DEPARTMENT OF PARKS AND COMMUNITY SERVICES

October 30, 2024

Subject: Flying Horse North Phase Filing No. 5 PUD Development Plan and Preliminary Plan Amendment (PUDSP-24-005) and Final Plat (SF-24-027)

The Park Planning Division of the Parks and Community Services Department has reviewed the Flying Horse North Filing No. 5 PUD Development Plan and Preliminary Plan Amendment and Final Plat and is submitting following comments and recommendations on behalf of El Paso County Parks. This application and the following comments and recommendations will be presented to the Park Advisory Board for their endorsement on November 13, 2024:

PUD PRELIMINARY PLAN MINOR AMENDMENT
 SITE PLAN 1

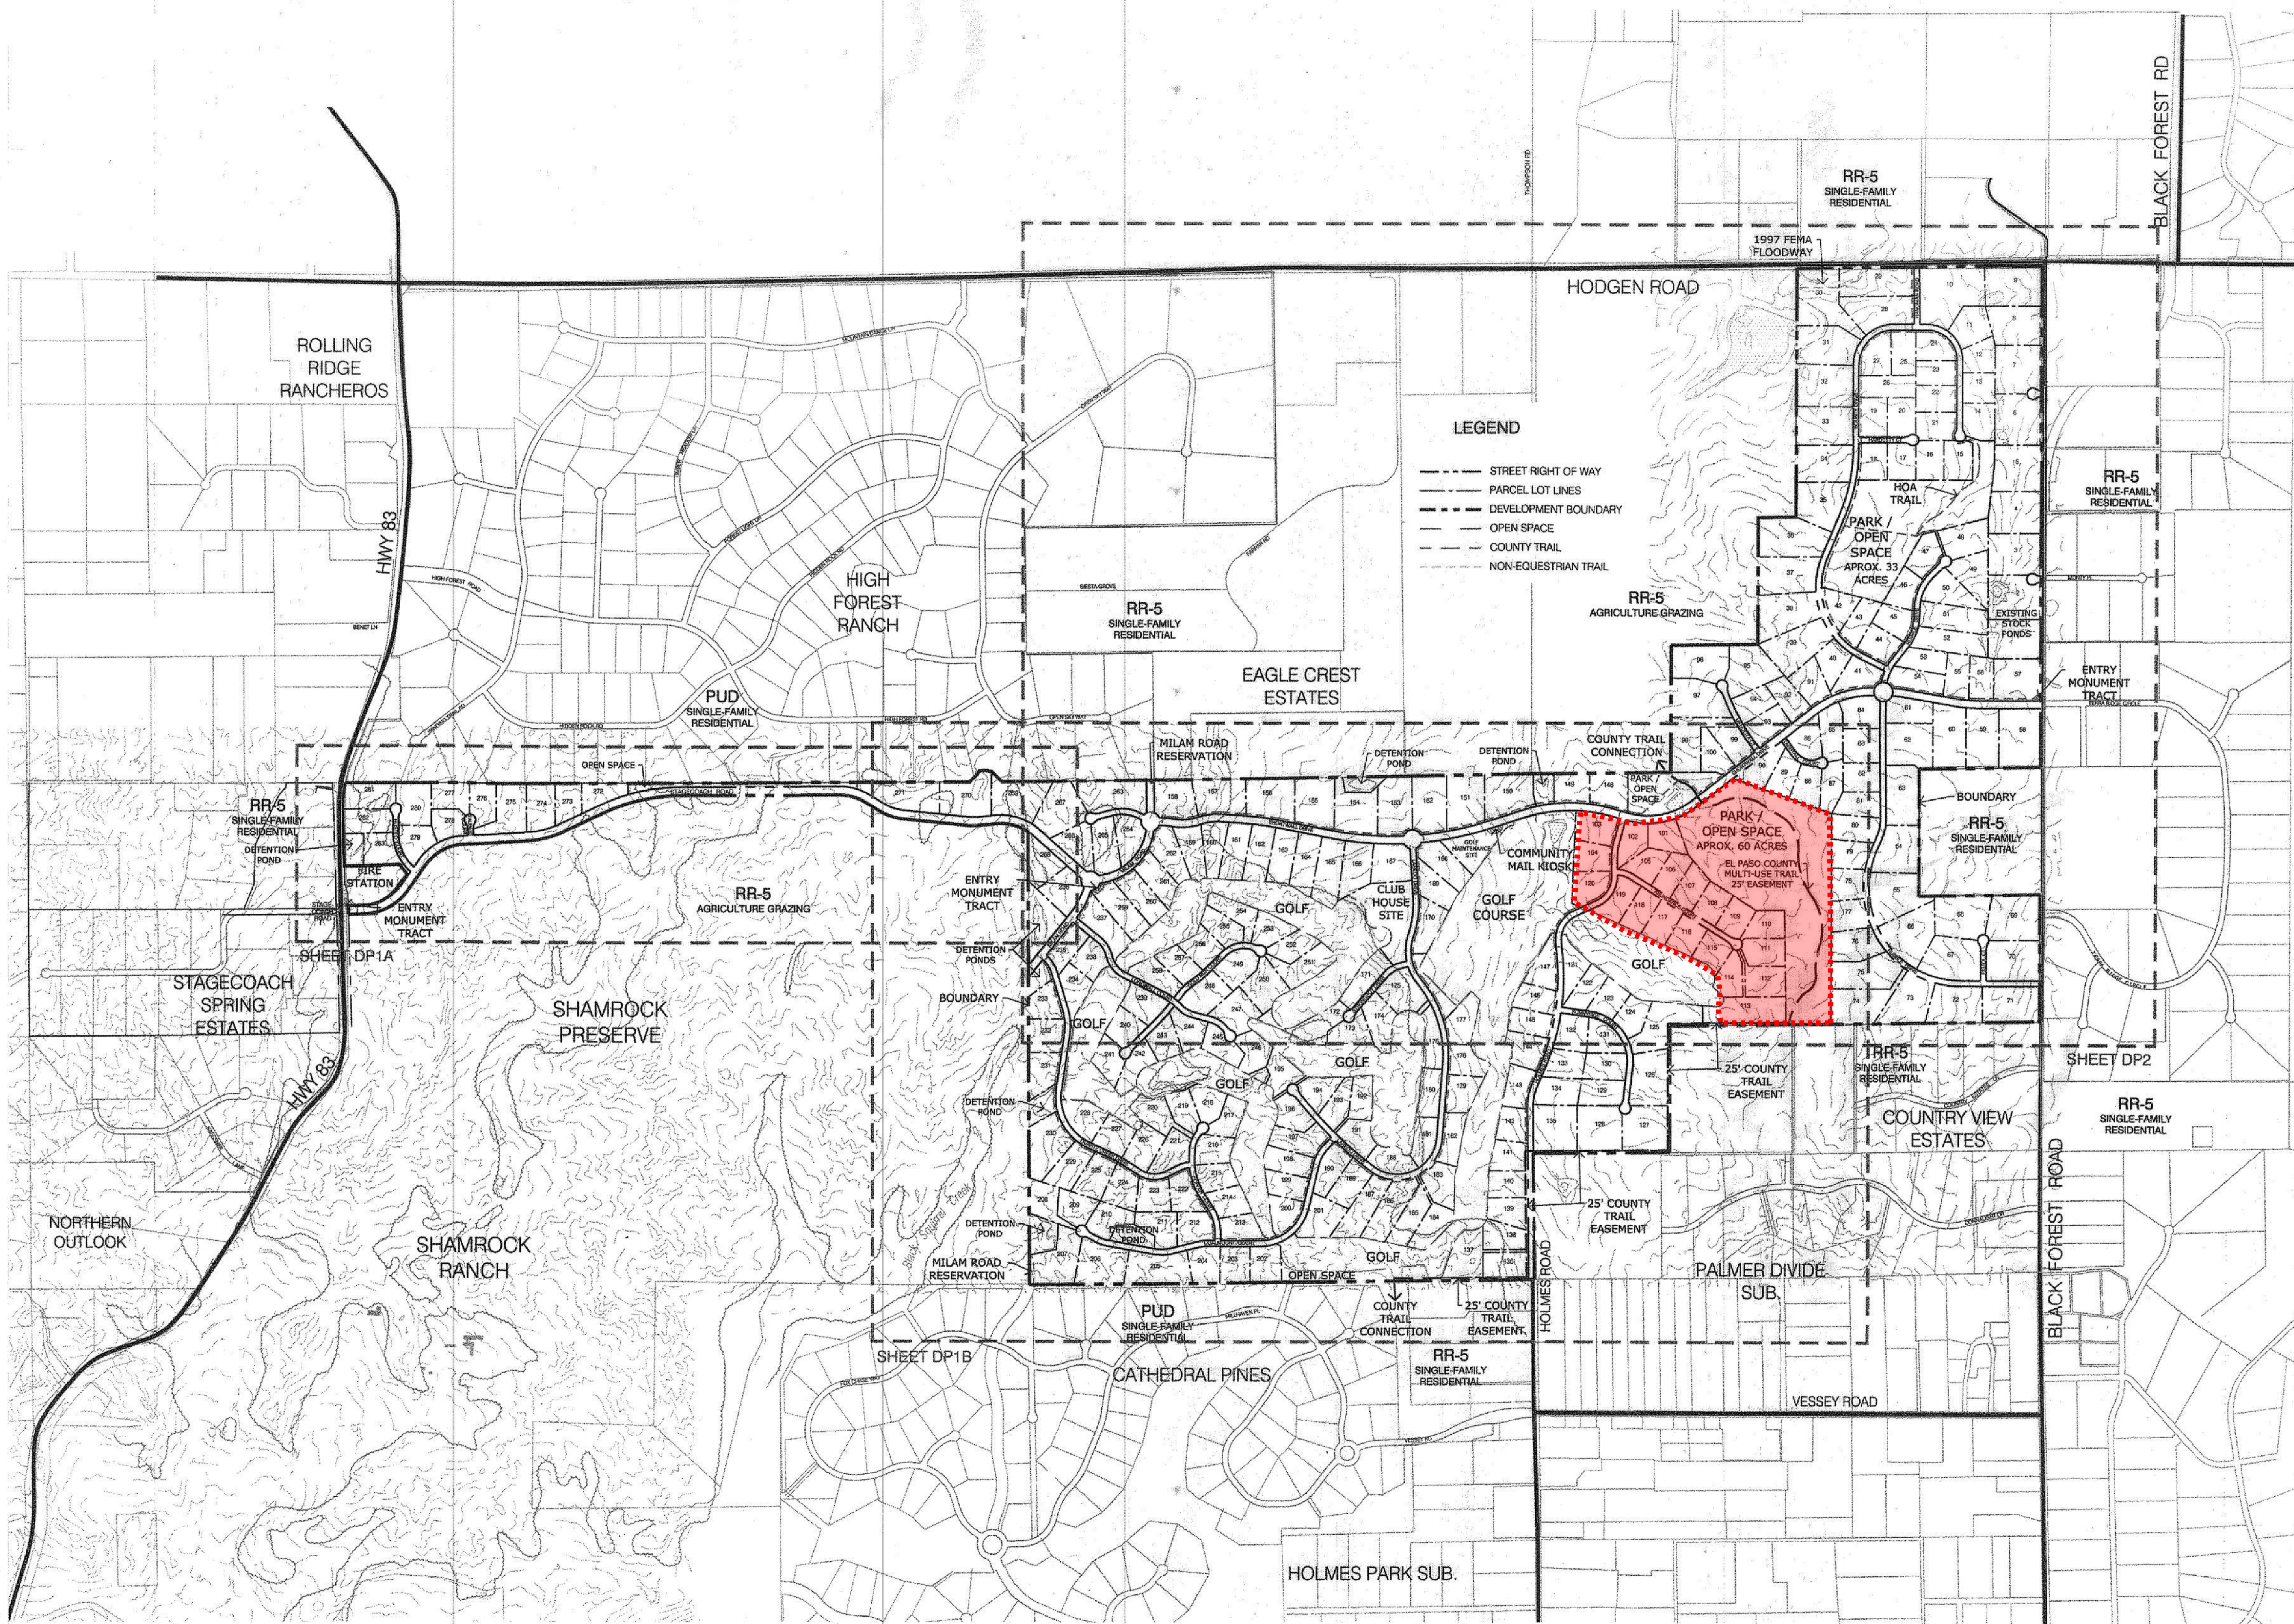
Furthermore, and as shown in the 2022 El Paso County Parks Master Plan, the Fox Run Regional Trail does traverse the northern boundary of Flying Horse North, following the south side of Hodgen Road as it travels to the west. The current Flying Horse North Trails Exhibit does not show this alignment and instead terminates the trail when it reaches Hodgen Road. Staff recommends the applicant add this particular section of the Fox Run Regional Trail to all future plans and final plats.

The Park Advisory Board recommends that the Planning Commission and the Board of County Commissioners include the following conditions when considering and/or approving the Flying Horse North Filing No. 5 PUD Development Plan and Preliminary Plan Amendment: (1) add the missing section of the Fox Run Regional Trail conceptual alignment to the Flying Horse North Trails Exhibit, located along the south side of Hodgen Road, terminating at the northwesternmost corner of the development; (2) designate and provide to El Paso County 25-foot wide public regional trail easement through Filing No. 5 that allows for public access, as well as construction and maintenance by El Paso County of the Fox Run Primary Regional Trail, and the easement be shown, noted, and dedicated to the County via the forthcoming Final Plat; and (3) fees in lieu of land dedication for regional park purposes in the amount of \$10,605 will be required at time of the recording of the forthcoming Final Plat. A Regional Trail Agreement may be acceptable alternative to regional park fees, provided the agreement is submitted by the applicant, reviewed and approved by the County, and executed prior to recording the Final Plat.
